## KITTITAS COUNTY FIRE MARSHAL'S OFFICE

February 23, 2009

Re: Akehurst Re-Zone and Plat

AKEHURST PLAT

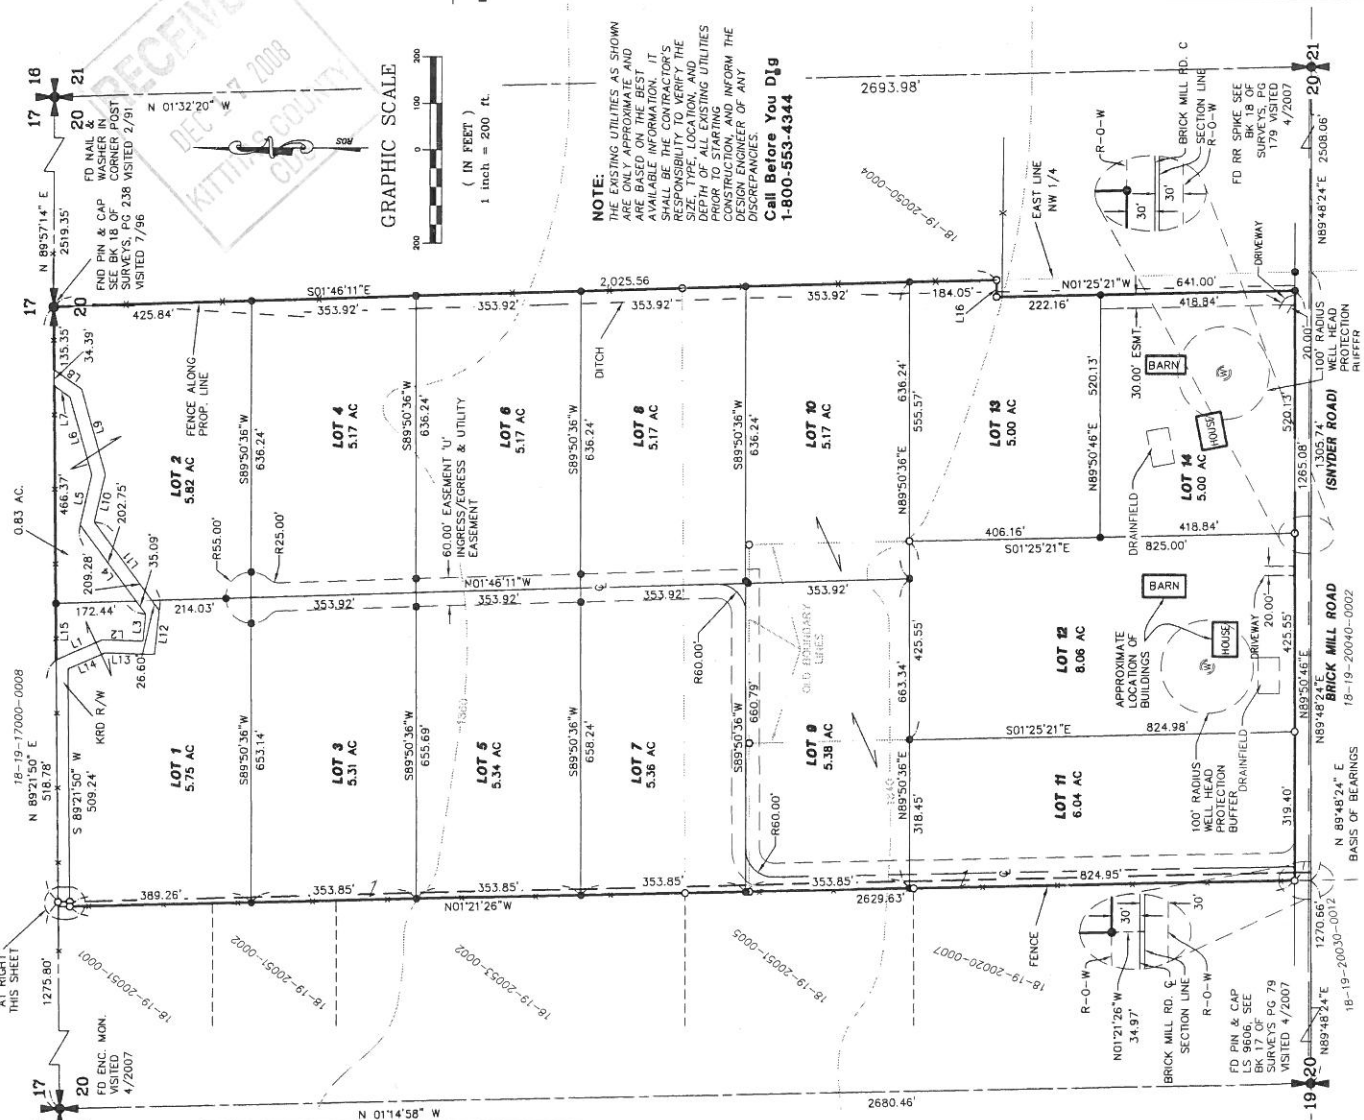
- Given the provided review documents, these residences will require fire flow of at least 1000 gpm (Gallons/Minute) for a duration of no less than 2 hours. A reduction in required fire flow of 50 percent, as approved, is allowed when the buildings are provided with an approved automatic sprinkler system.

- An approved water supply capable of supplying the required fire flow for fire protection shall be provided. A hydrant or standpipe system with an adequate source of water (supply), a distribution system and adequate pressure for delivery shall be installed for this plat. Hydrant spacing shall comply with International Fire Code and its appendices' requirements.

- A separate permit & deposit shall be required for installation of the hydrant or standpipe system.
- Access requirements shall be per the 2006 International Fire Code Appendix D. The turnaround shall have a 70' radius.

- Turnouts may be required along the two north-south portions of the road. Driveways will suffice as turnouts.
